Planning Application Ref: Y/9/21/DOC

Location: Land to the south of Ford Lane and East of North End Road, Yapton, BN18 0DS

Description of works: Approval of details reserved by condition imposed under ref Y/82/20/RES relating to Condition Nos 5 - non-dig surfacing method and 8 - electric vehicle charging strategy

Drawing Title Sections through public right of way footpath 357

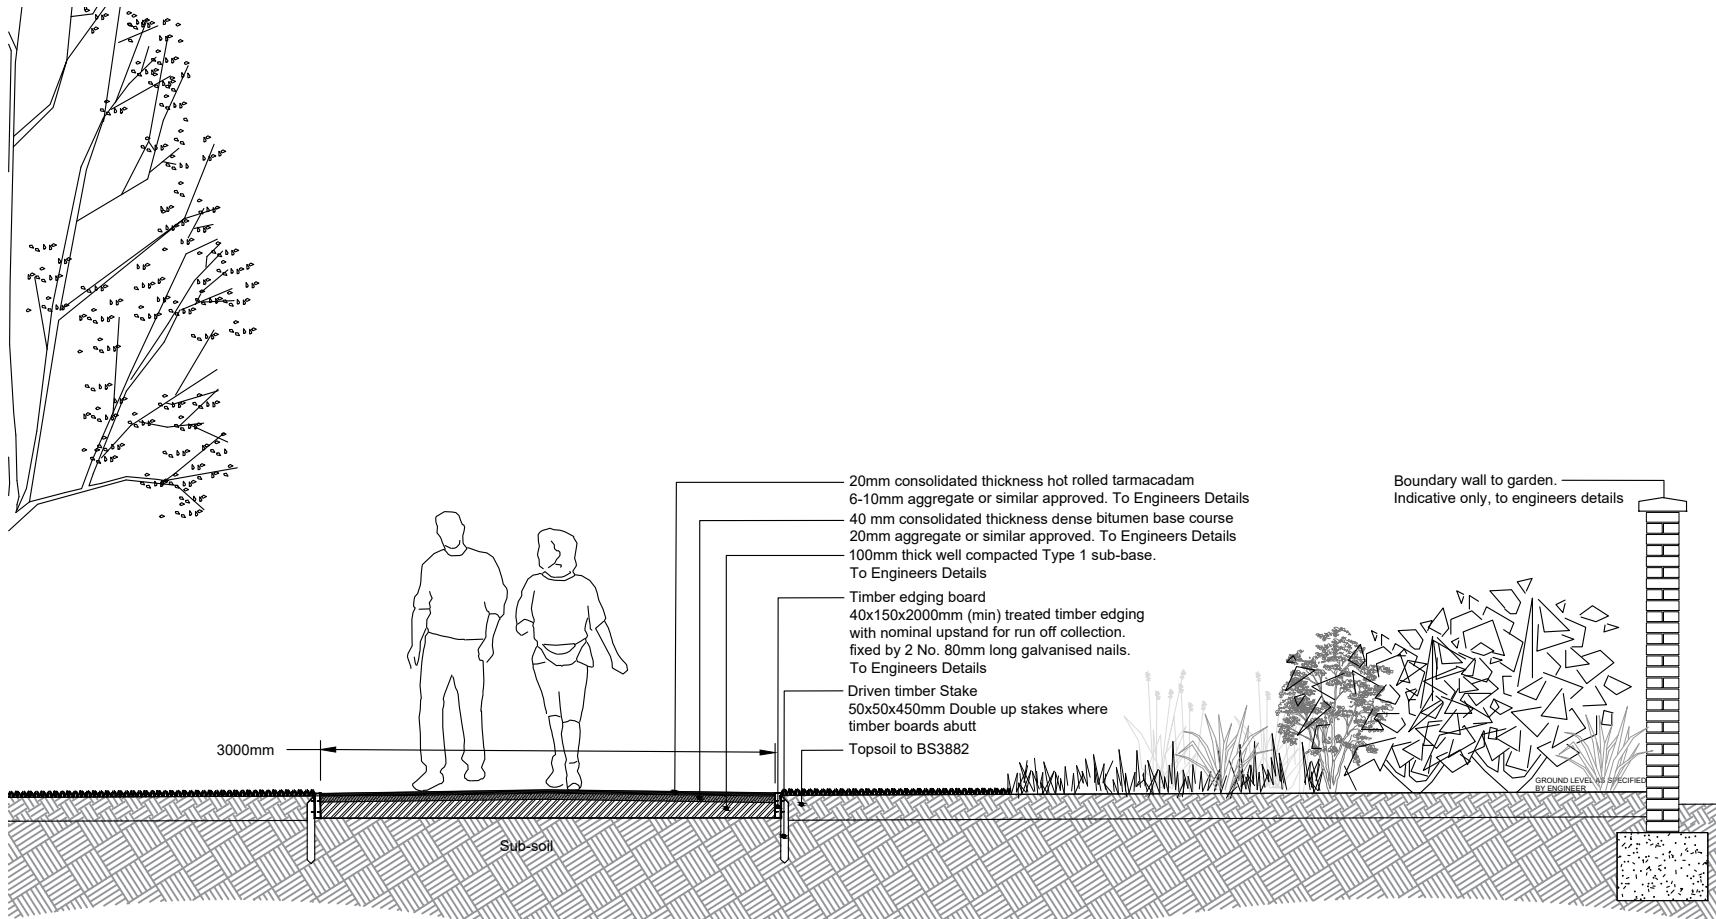
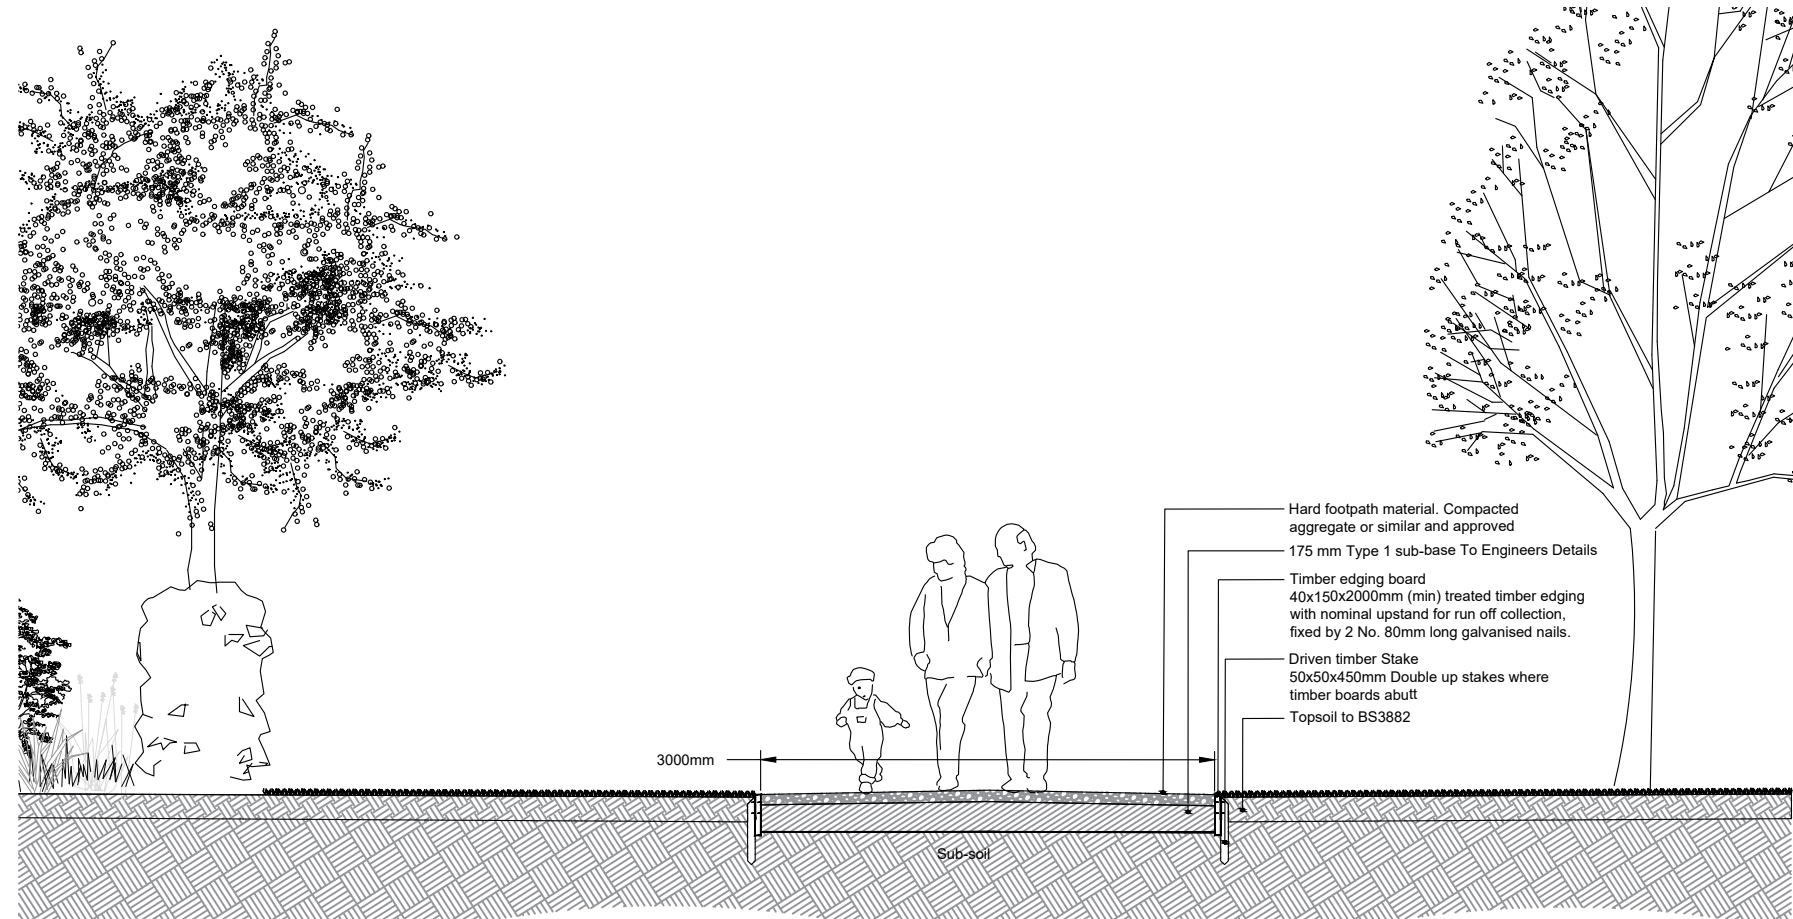
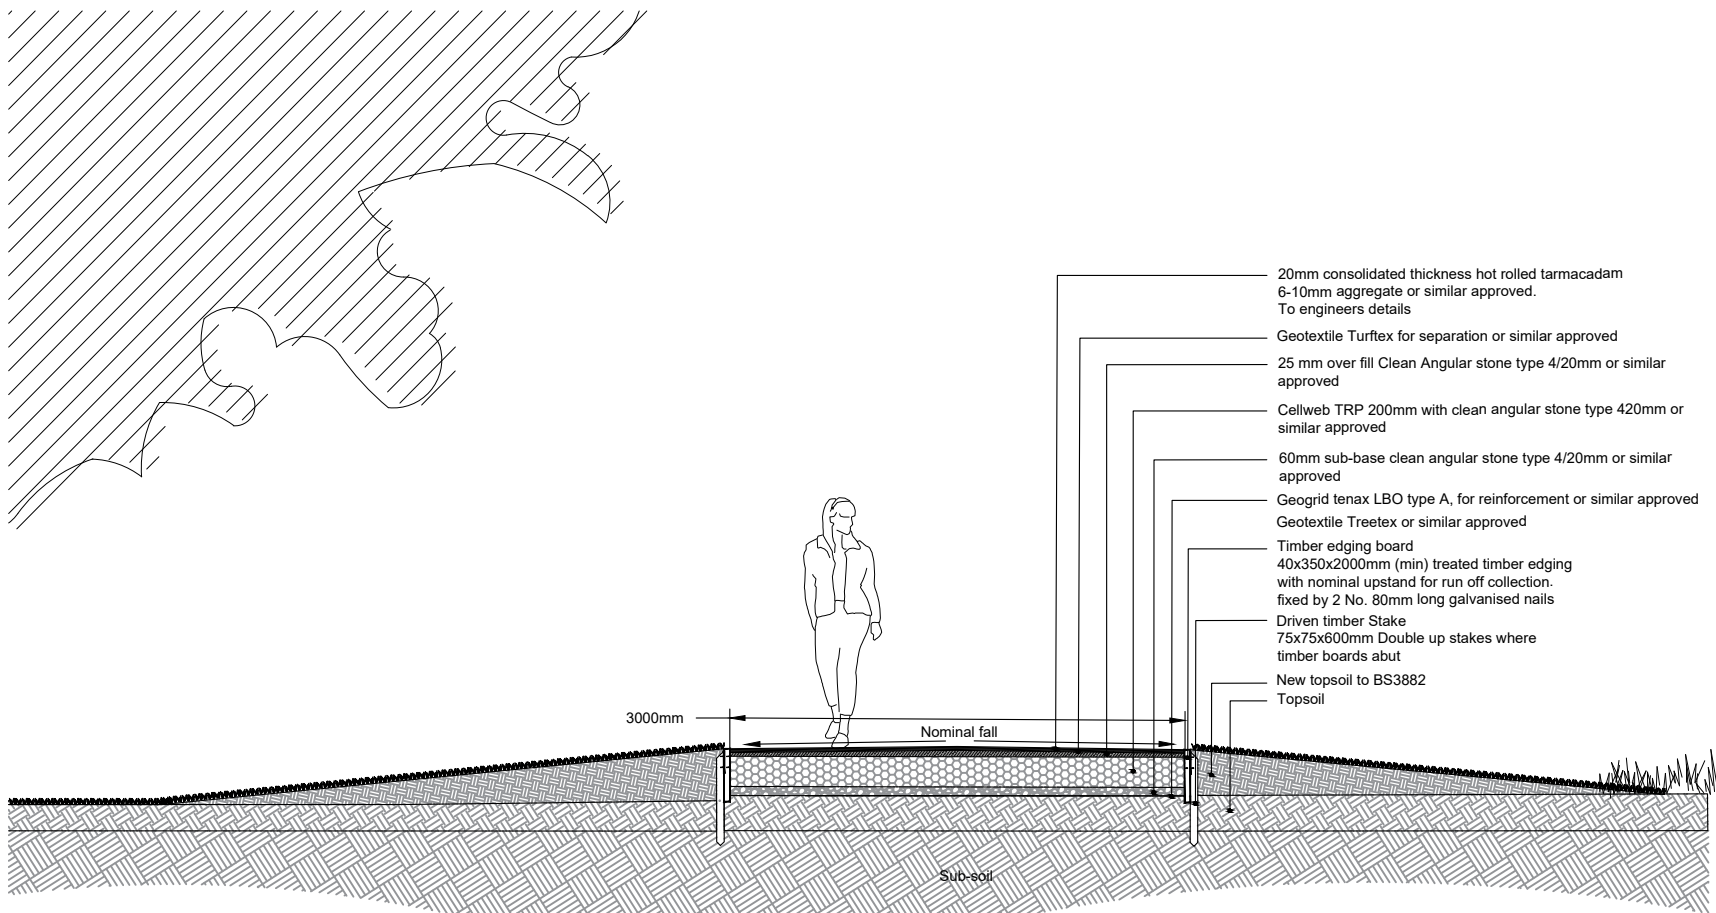
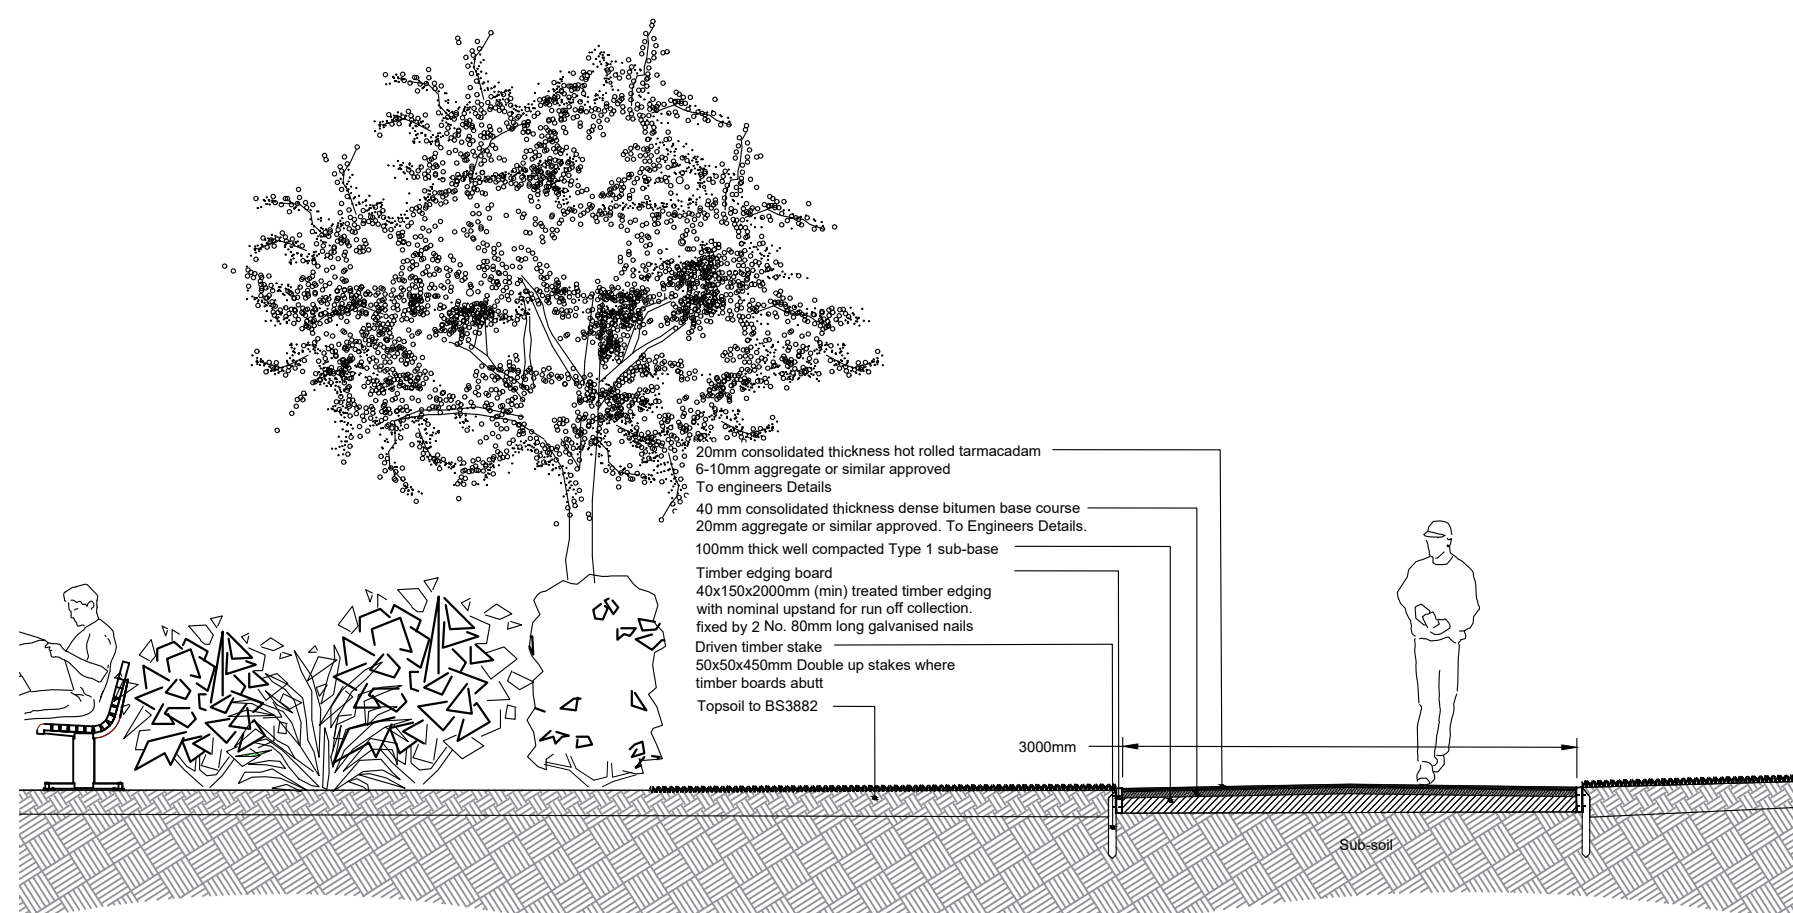
- I have considered this application by means of a desktop review, using the information and plans submitted.
- The applicants have employed fabrik landscape architects to prepare a drawing (dwg. no. 0402, Rev PL02) illustrating and describing a 'No-dig' method of footpath construction. I approve of the specification proposed therein.

- I am satisfied that the applicant has met the requirement of Condition 5.
